St Laurence, Caversfield

Response to the North West Bicester Development Proposal, Outline Planning Application 21/01630/OUT

12th October 2021

DRAWING TITLE  
**PROPOSED PEDESTRIAN CROSSING TO CHURCH**

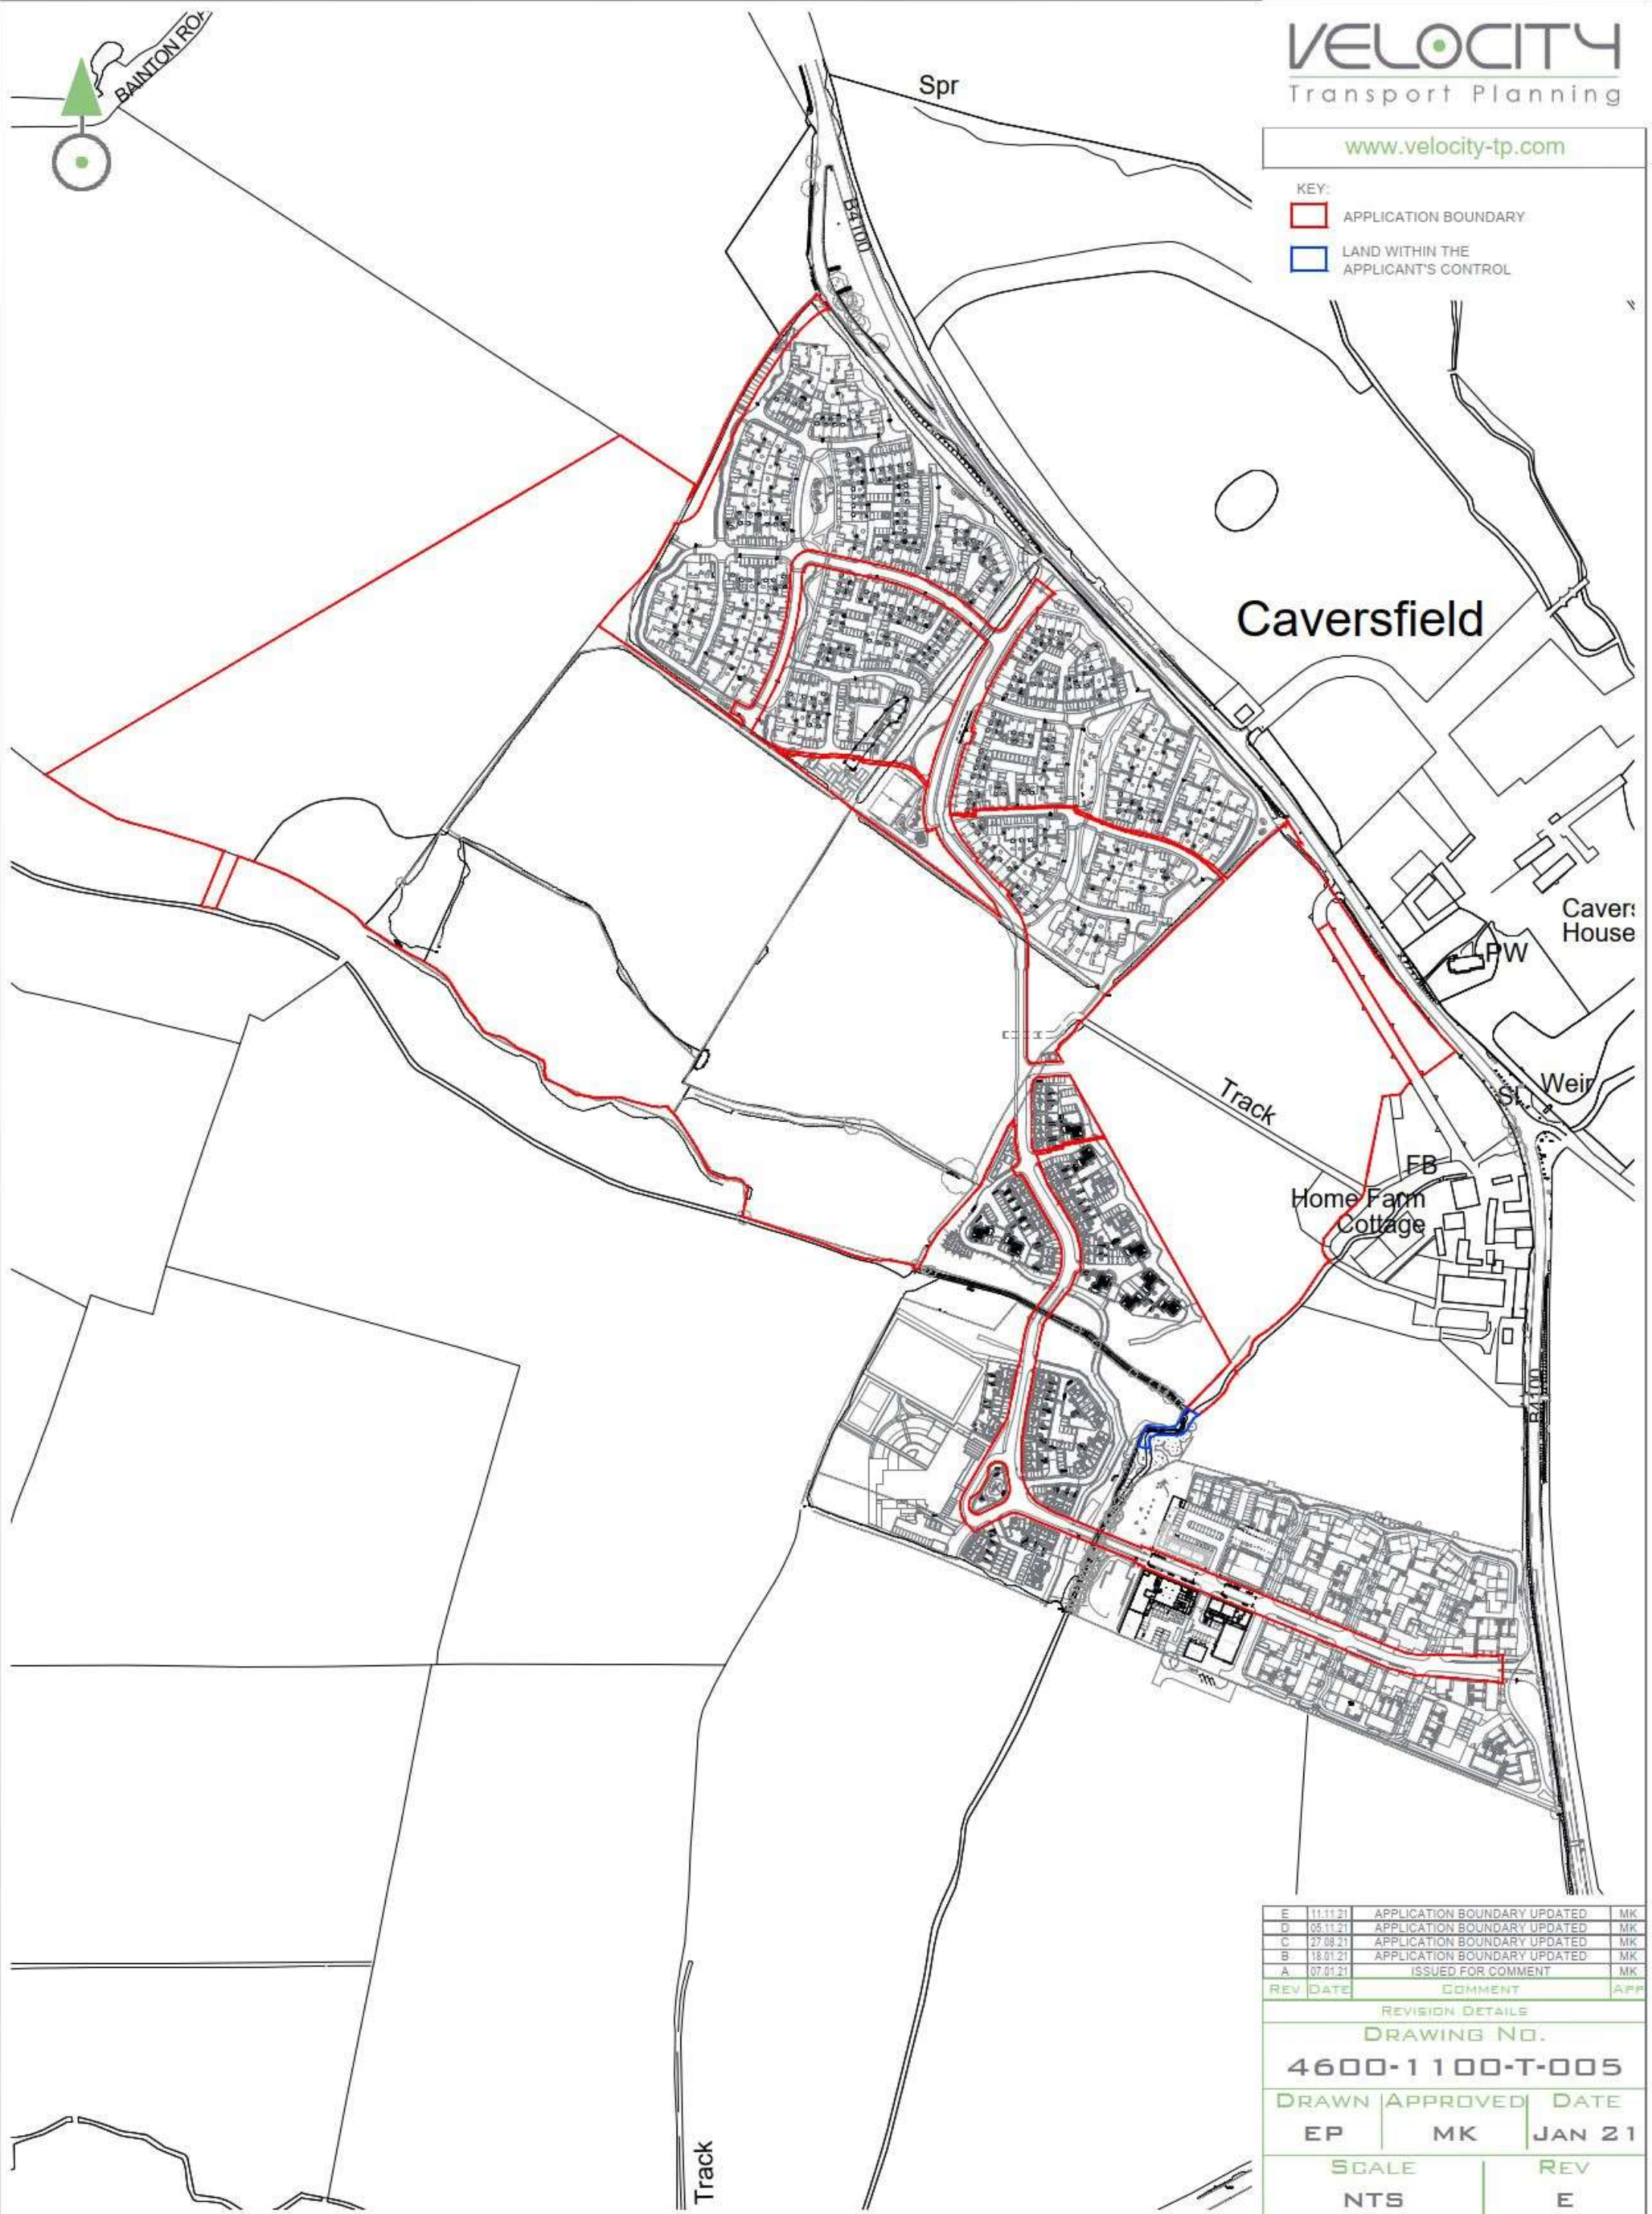
The outline proposal talks about ‘a development that integrates with its context’, and proposes a vista along the axis of the church as a key benefit for new residents, so it would seem natural to provide people with the means to access the church. This is not included in the proposal in its current form despite the District Councils’ statement in their letter of 2nd February that provision of a pedestrian crossing of the B4100 to St Laurence’s will be a requirement. Crossing the B4100 to reach the church is already a matter of concern.

Currently worshippers and visitors have to park on the access drive to Home Farm, walk along the grass verge and cross the road opposite the gate into the churchyard. Traffic on this road is often heavy and fast and there is a level of risk in crossing the road. With the development of this scheme, the number of people wishing to come to the church can only increase. We are already seeing the beginning of this with Elmsbrook residents coming to the church. Creating a road on the axis of the church to use it as a viewpoint for the development can only increase the likely numbers coming to St Laurence’s.

If this scheme is to be given planning consent, it is essential that a safe road crossing is provided, with an appropriate access path along the verge from the estate and the Home Farm entrance to the crossing place. There will need to be paths in the development that lead towards the church.

5. If the scheme is to be granted consent, the provision of a crossing for pedestrians should be a condition set by the planning authority, with an appropriate access path along the verge from the estate and the Home Farm entrance to the crossing place. The development should include paths that lead towards the church.

DRAWING TITLE  
**CONSTRUCTION ACCESS  
OVERVIEW PLAN**

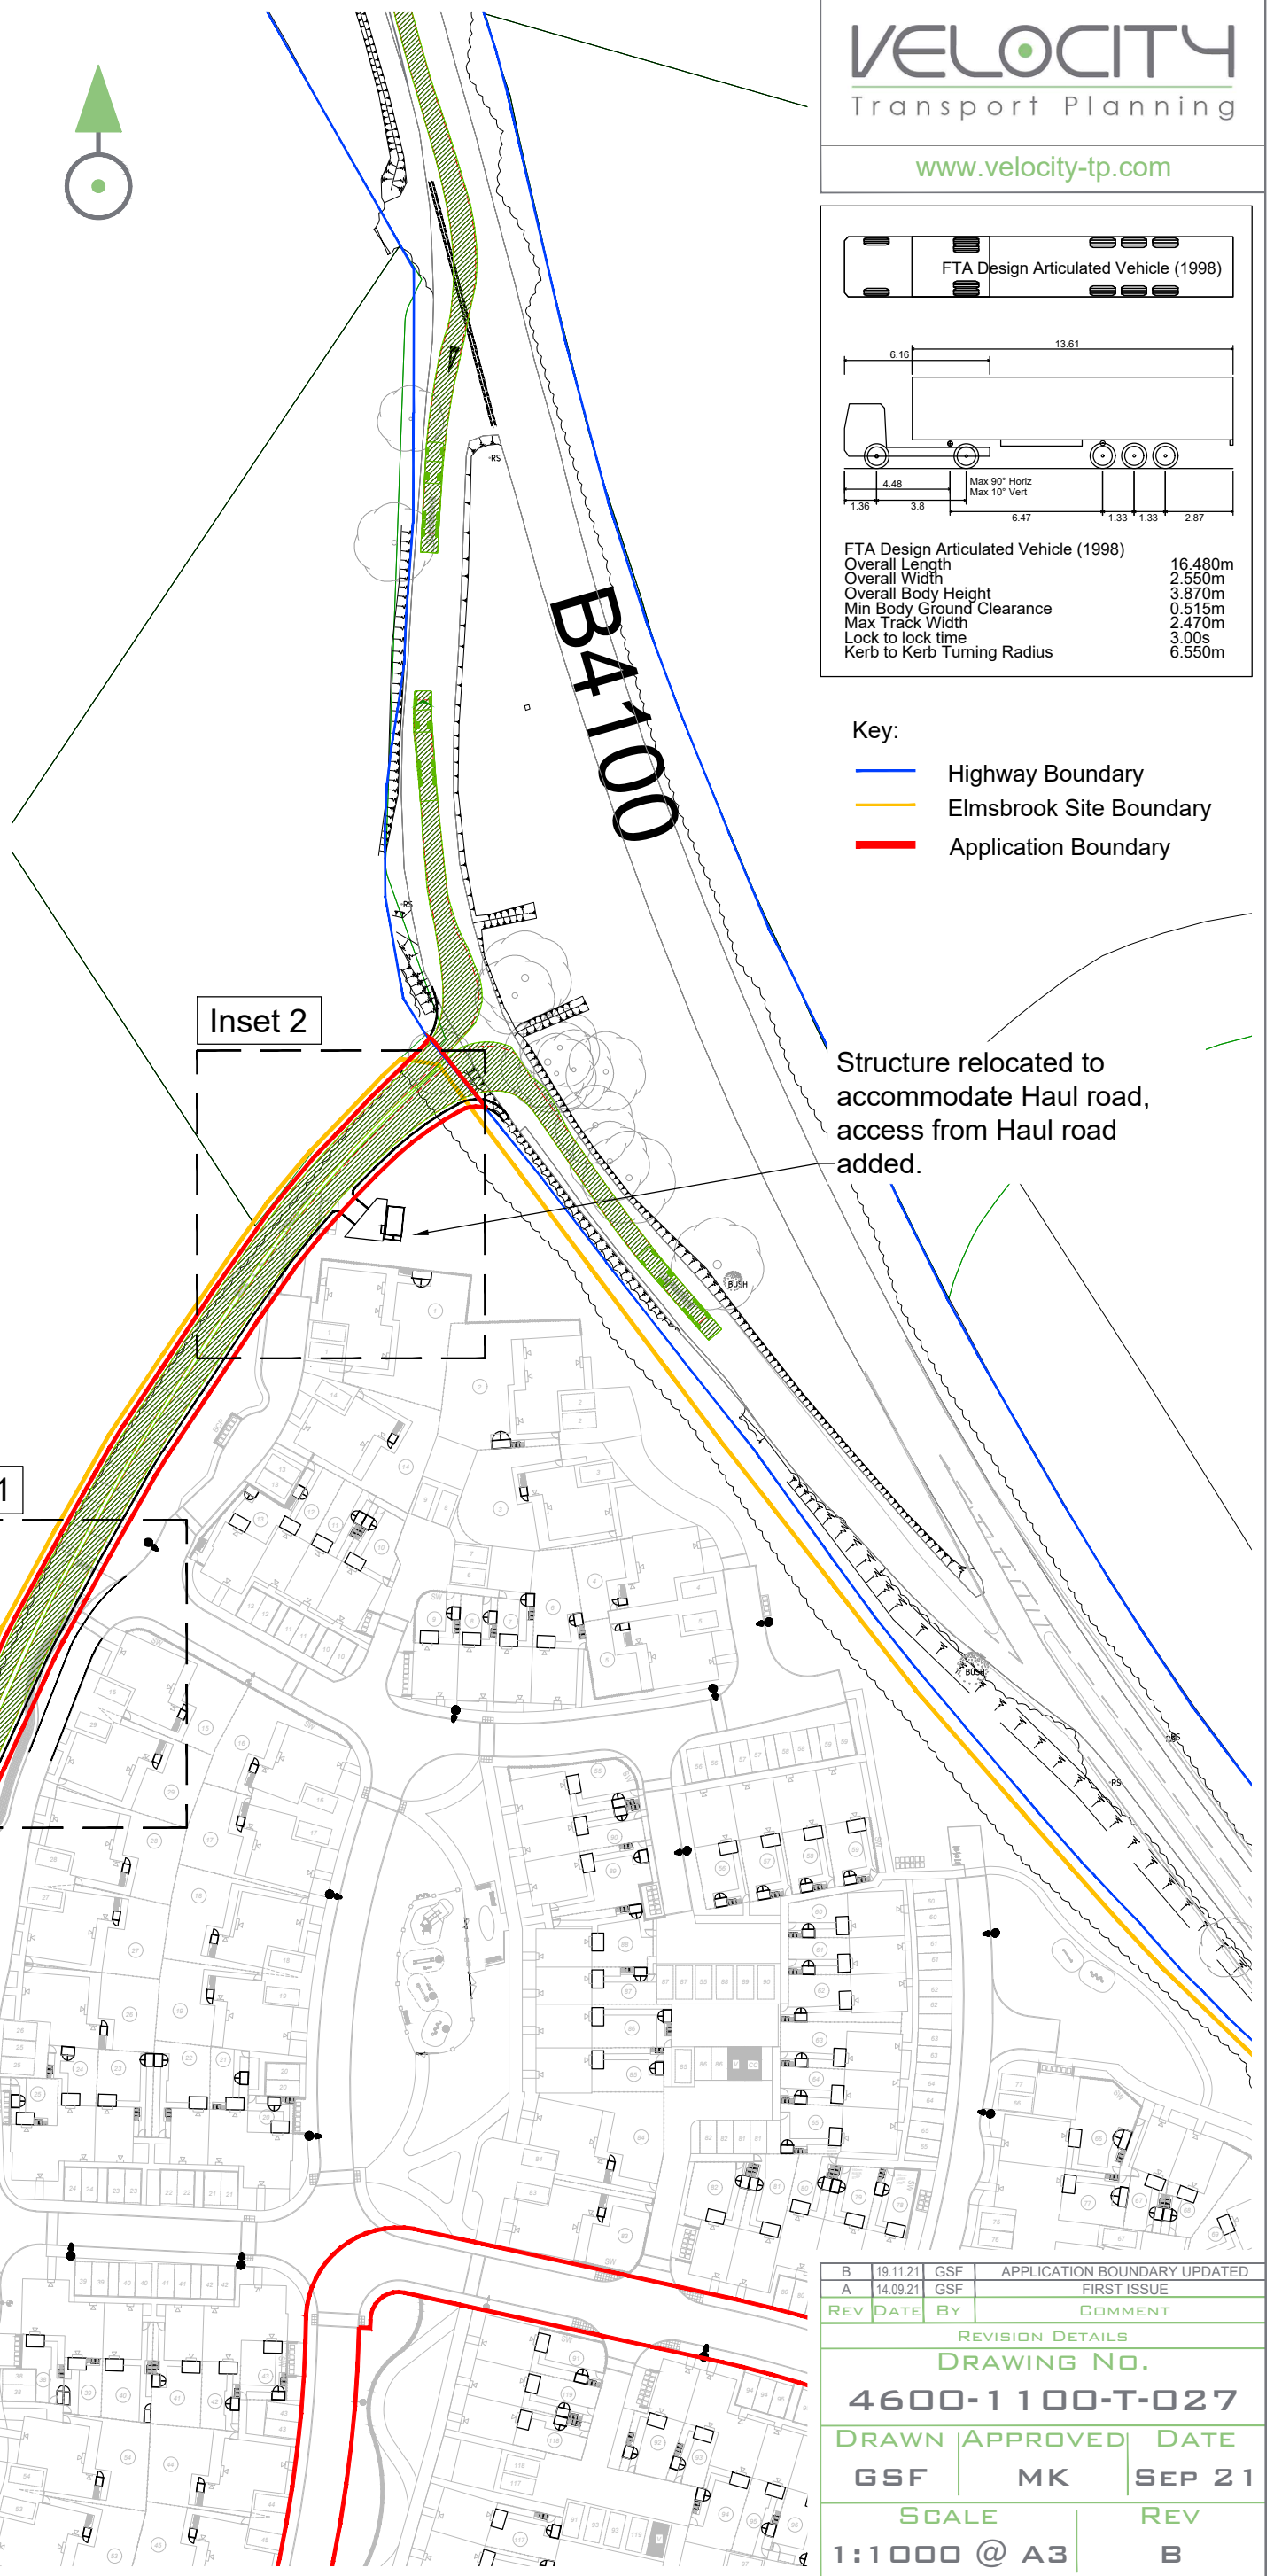
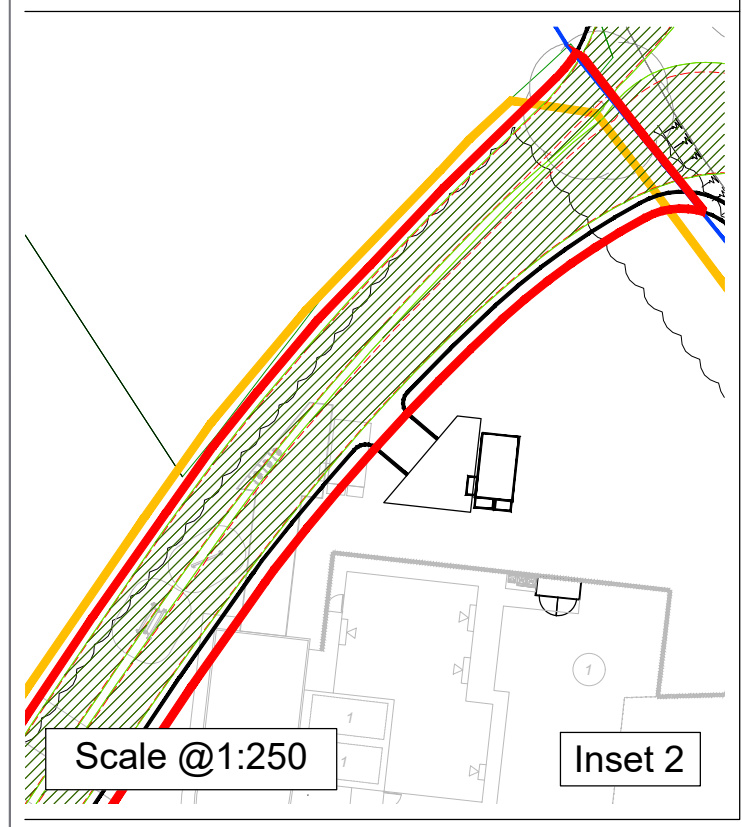
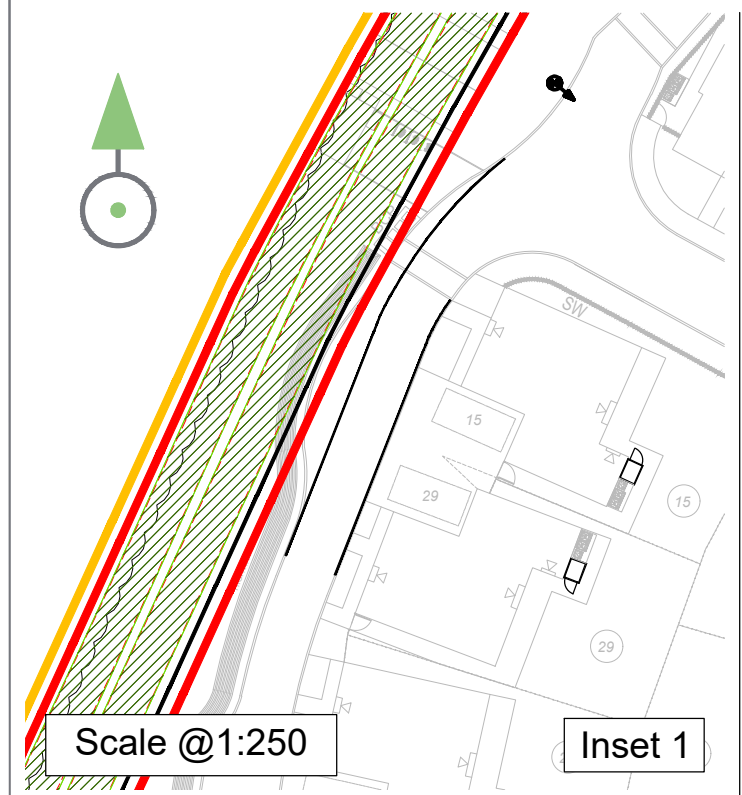
An issue during the construction phase, which will last for some years, will be the proximity of the eastern works entrance to the entrance to Home Farm. These are very close together and it is difficult to see how both can be safely used at the same time. This may affect people trying to visit the church, and wishing to park in the Home Farm drive.

6. The provision of car parking which could be used by visitors to the church should also be a condition.
7. The feasibility of safely using both the Home Farmhouse entrance and the eastern works access at the same time should be further examined and, if necessary, the eastern works access should be placed elsewhere.
